From: Sarah Featherstone [REDACTED]
Sent: 27 September 2019 10:04
To: Anita Gardner <Anita.Gardner@arun.gov.uk>
Cc: Martyn White <Martyn.White@arun.gov.uk>
Subject: Thatch Cottage applications CM/42/19/PL and CM/43/19/L

Thatch Cottage:

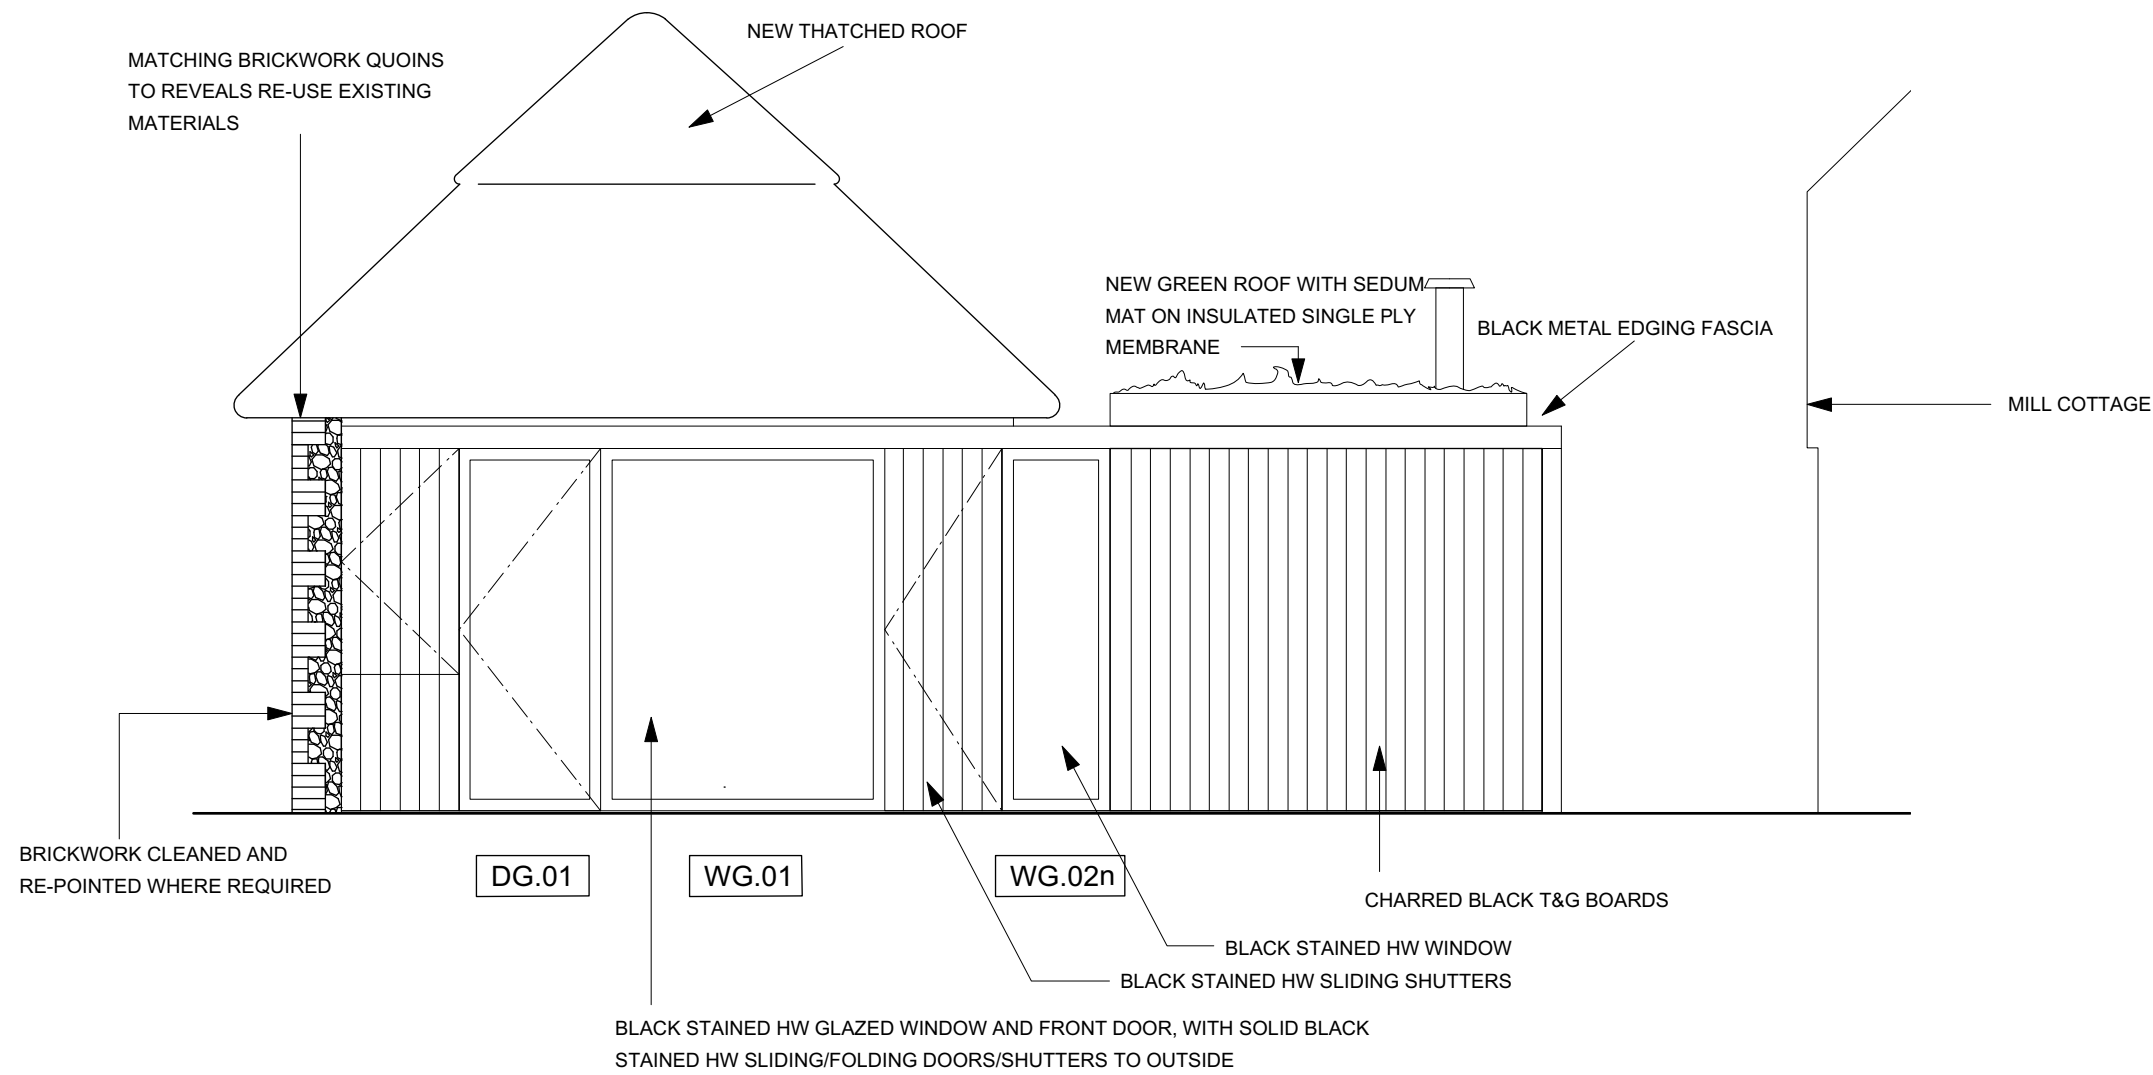
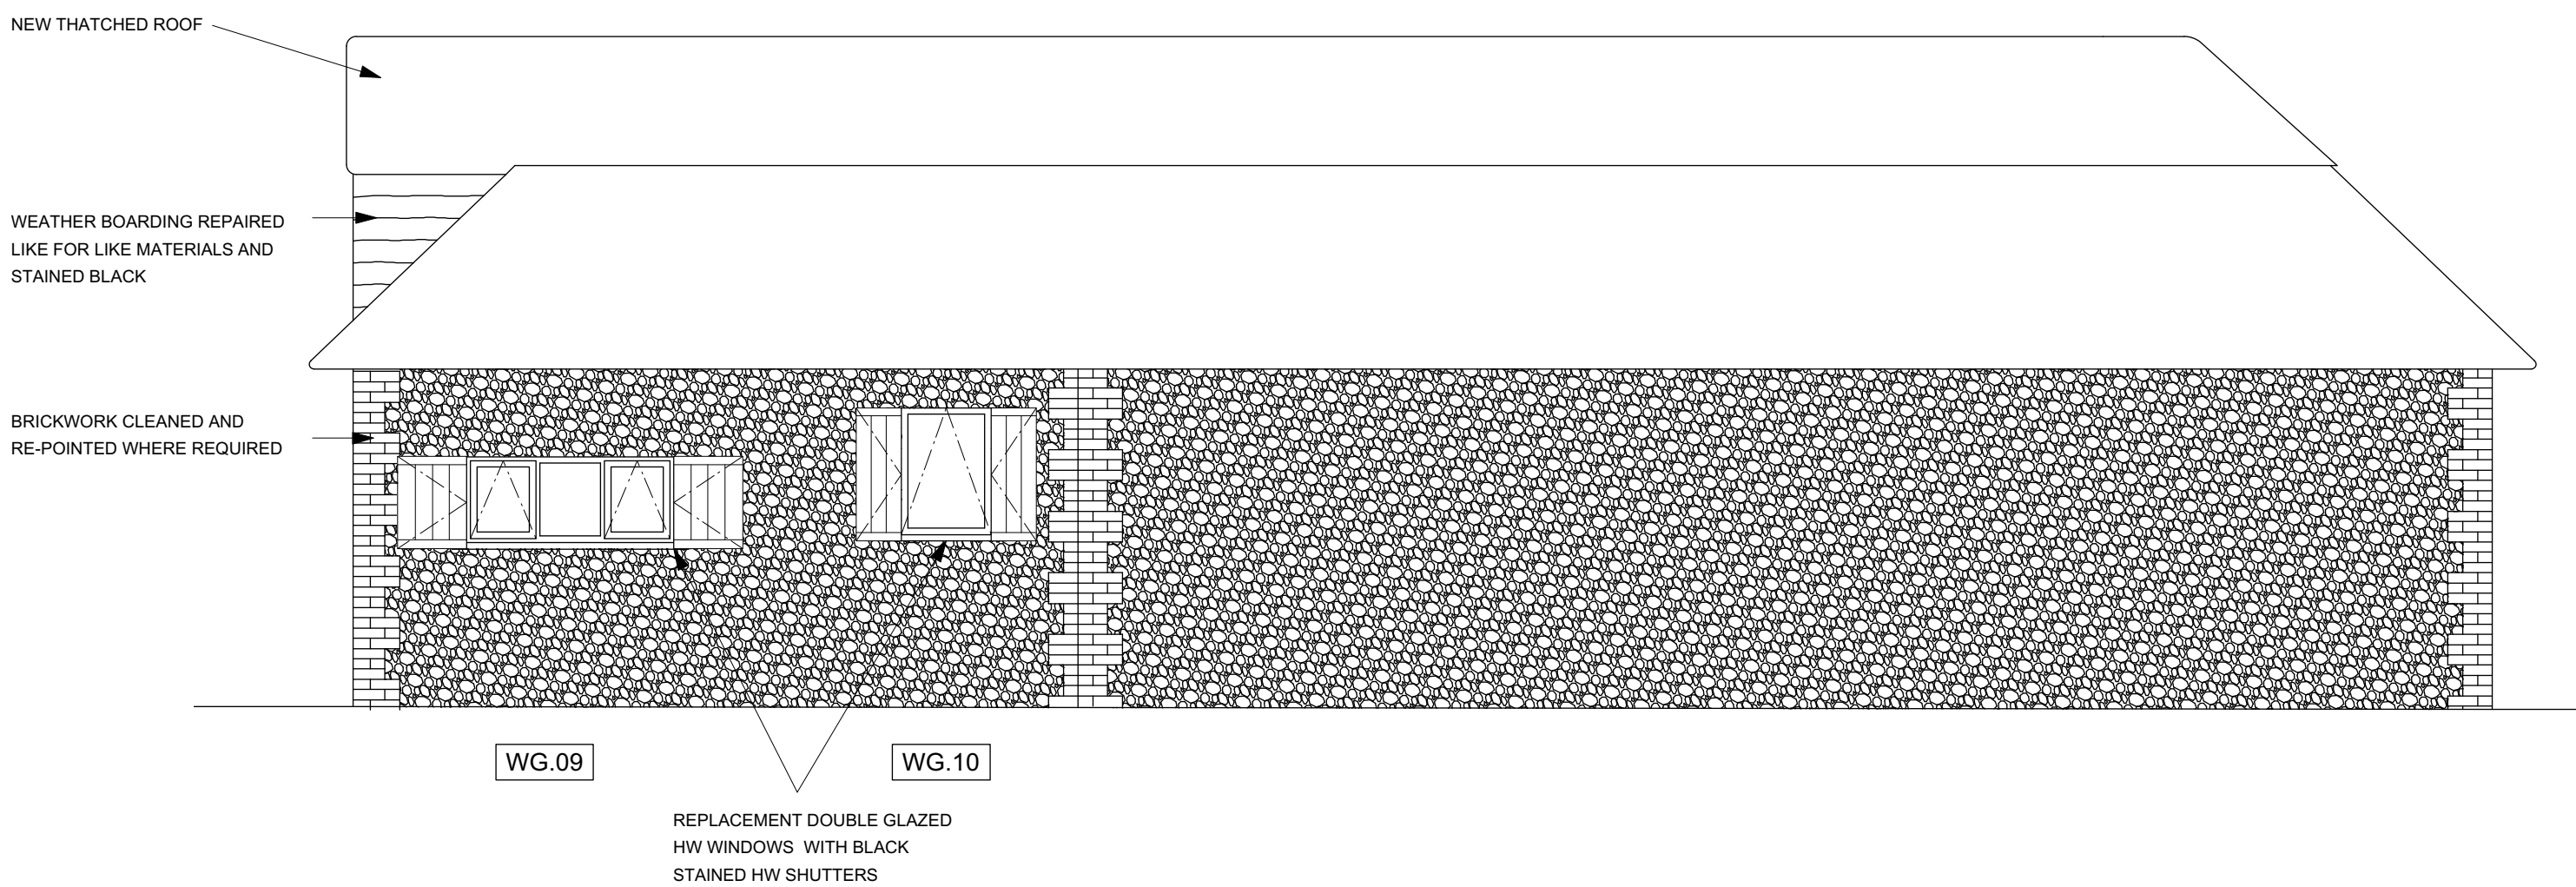
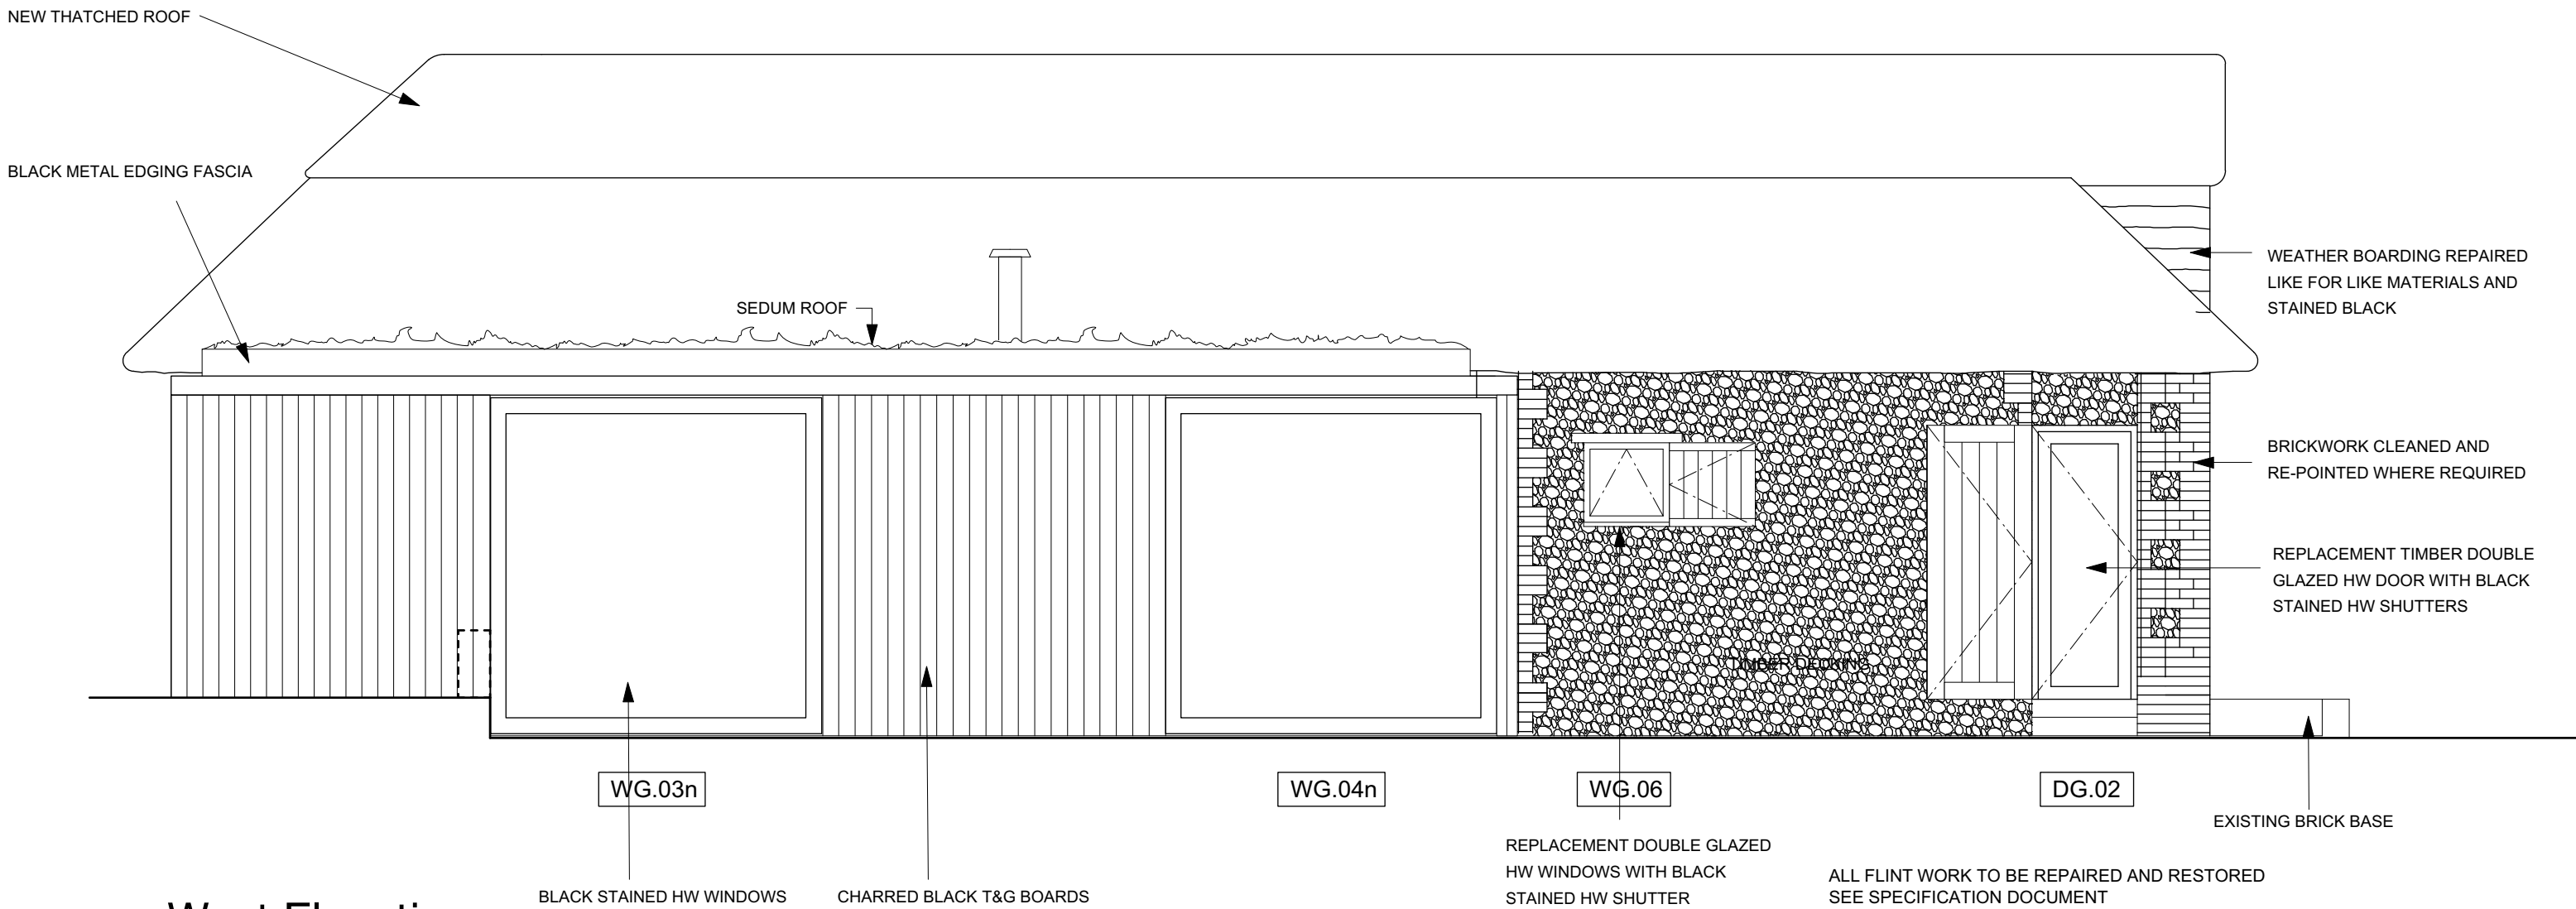
- We confirm all windows have shutters.
- No wall to to edge of southern terrace, there is brick faced side to ramp where it is above grassed ground.
- Private garden - this is not enclosed but Thatch Cottage terraced area opens on to it so we envisage it being used primarily by Thatch Cottage occupants. It will be grassed so we did not think a landscape scheme would be required. Please confirm.
- MW states that the repair and replacement of thatch roof will be acceptable if it reflects those on the existing roof. We can confirm we submitted a Thatch Methodology Statement with the application which confirms the replacement thatch will match what is there on the existing roof. Please confirm no further information is required.
-
- **2. Additional details which we can issue next week:**
- T&G board detail used on external wall cladding of new extension
